Reference No:	2023/62/93616/W
Site Address:	22A, Stainecross Avenue, Crosland Moor, Huddersfield, HD4 5HZ
Description:	Erection of single storey extension and rear dormer extension and associated alterations
Recommending Officer:	Laura Yeadon

DECISION – CONDITIONAL FULL PERMISSION

HOUSEHOLDER DELEGATED REPORT

Proposed North Elevation (Front)

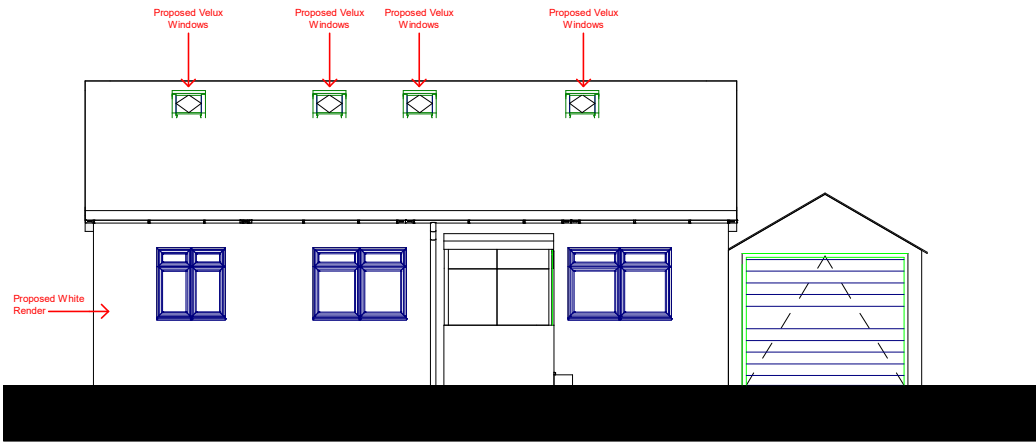
The alterations to the property includes a minor increase in the eaves and ridge height of the property by adding an extra course of brick work. In addition, a fourth rooflight would be inserted into the front elevation roof slope and a ground floor opening would be inserted into the west side elevation of the property.

4. Notwithstanding the submitted plans, following the substantial completion of the single storey extension to rear the render finish to the host property and single storey extension to rear shall be completed in a cream colour finish which shall be retained thereafter

Proposed South Elevation (Rear)

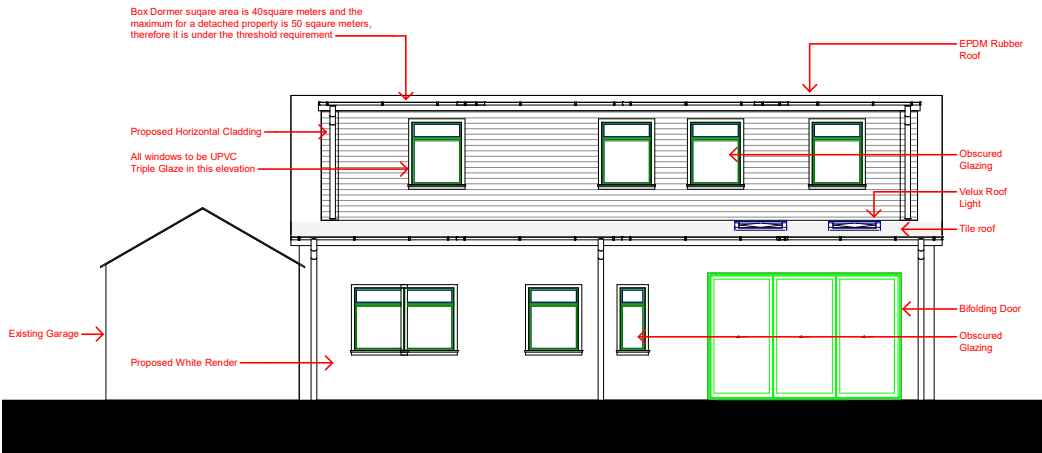
YES / NO	SUMMARY
Negotiations/Amendments during course of application	Yes	It was requested that the first floor extension was removed and replaced with a dormer to allow the original roof line to be clearly read and less prominent within the street scene – Amended plans received 25.1.2024
Parish/Town Council comments sought	No	Not applicable
Planning History	Yes	2020/92595 – Erection of detached garage – Conditional Full Permission – permitted development rights removed for windows and doors

The proposed dormer extension would be set in from the side elevations of the property by 0.4 metres spanning the remaining width of the roof slope. The dormer would be set up from the gutter line of the single storey extension by 0.4 metres and would be set down from the ridge of the property by 0.1 metres. It is proposed that the construction materials of the dormer would be horizontal cladding with a EPDM rubber roof.

extension in from this boundary and the layout of the site provides suitable justification for the scheme as proposed in this case.
Dormer extensions should:		
relate to the appearance of the house and existing roof		No – Whilst the dormer would be set within the confined of the roof elevations it is a large, flat roof structure. However it is noted there is a realistic fall back that a dormer of similar size and scale could be constructed to the rear roof slope by utilising permitted development rights. This is considered to be justification, in this case, for the scheme as proposed.
be designed in style and materials similar to the appearance of the existing house and roof;	Horizontal cladding proposed – can be conditioned to be grey cladding to be in keeping with the colour finish of the existing roof	
not dominate the roof or project above the ridge of the house		The dormer is a large feature within the rear elevation however there is a fall-back position in terms of permitted development

be set below the ridgeline of the existing roof and within the roof plane		The proposal would comply with this in terms of the side elevations and ridge of the roof, and would read as being within the roof plane in conjunction with the single storey extension to rear. This is considered sufficient justification for this

3. Notwithstanding the submitted plans, the dormer to the rear hereby approved shall be of a dark grey colour finish to the front and cheeks. The colour finish approved by this condition shall be thereafter retained.
